Householder Proforma

2023/0056

28 Tenters Green, Worsbrough, Barnsley, S70 5HG

The applicant is seeking approval for the erection of a single storey side extension to the existing garage and alteration to the roof design which effectively raises the roof ridge height from 3.65m to 4.05m. It is a resubmission compared to the previous refused application ref 2022/0316, which was subsequently dismissed at appeal.

Proposed Front Elevation
Scale 1:100

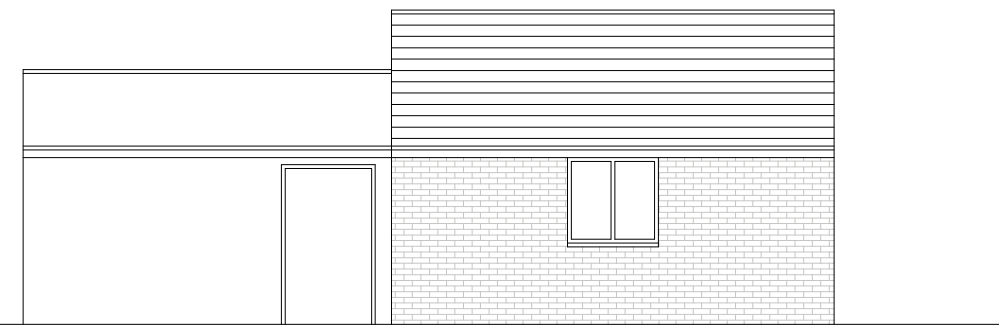
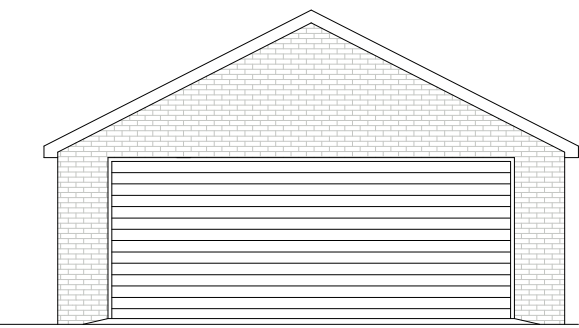
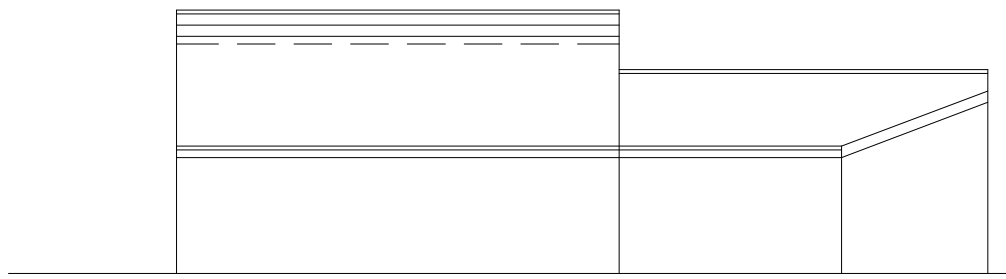
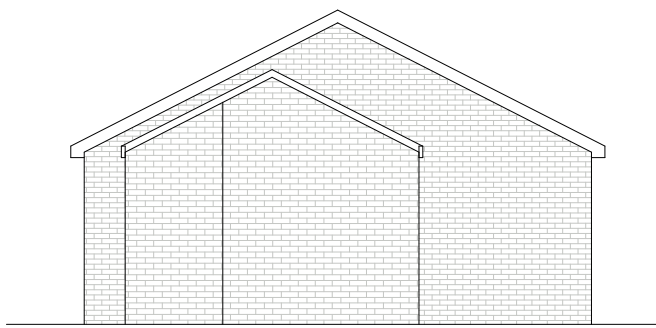
Yes / No (include comment if required)
1. single storey?	Yes
2. height to eaves 2.5m or less?	Yes
3. sympathetic design and materials to main dwelling?	Yes (The proposal is a re-submission of a much larger garage extension (Application ref. 2022/0316) which was refused and dismissed at appeal – see full reason for refusal above. The primary

concerns raised previously were in relation to the size and scale of the proposed extension and the resultant total size of the garage. Alongside this, the proposed garage was to be forward of both the front elevation of the garage and principal elevation of the dwelling. The refused application was therefore considered to have a detrimental impact on the character of the dwelling and the street scene in that it does not harmonise with the existing layout of development in the area, in what is an open and visible corner plot. The proposed extension to the garage (10sqm) is significantly smaller in size and scale than the one previously proposed (40sqm) Also, the total footprint size of proposed garage now measures 56sqm compared to 86sqm (under 2020/0316). The proposed total footprint is now more in line with the expected footprint for domestic outbuildings and is now considered to be subservient to the host dwelling. Additionally, there were concerns raised during the assessment of 2022/0316 that the proposed garage was forward of the principal elevation of the dwelling and therefore was more prominent in the street scene. The proposal has rectified these concerns with the extension being brought in line with the existing garage frontage and the positioning of the garage is now acceptable. The proposal seeks to raise the roof ridge height of the garage from 3.65m to 4.05m but retains the existing roof style. The raise in roof height is not considered to be excessive. On balance, the amended scheme/resubmission has alleviated the previous concerns of application ref. 2022/0316 in regard to the size and scale of the garage now being subservient to the host dwelling and the common building line no longer being disrupted. The proposed development is now considered to be acceptable).
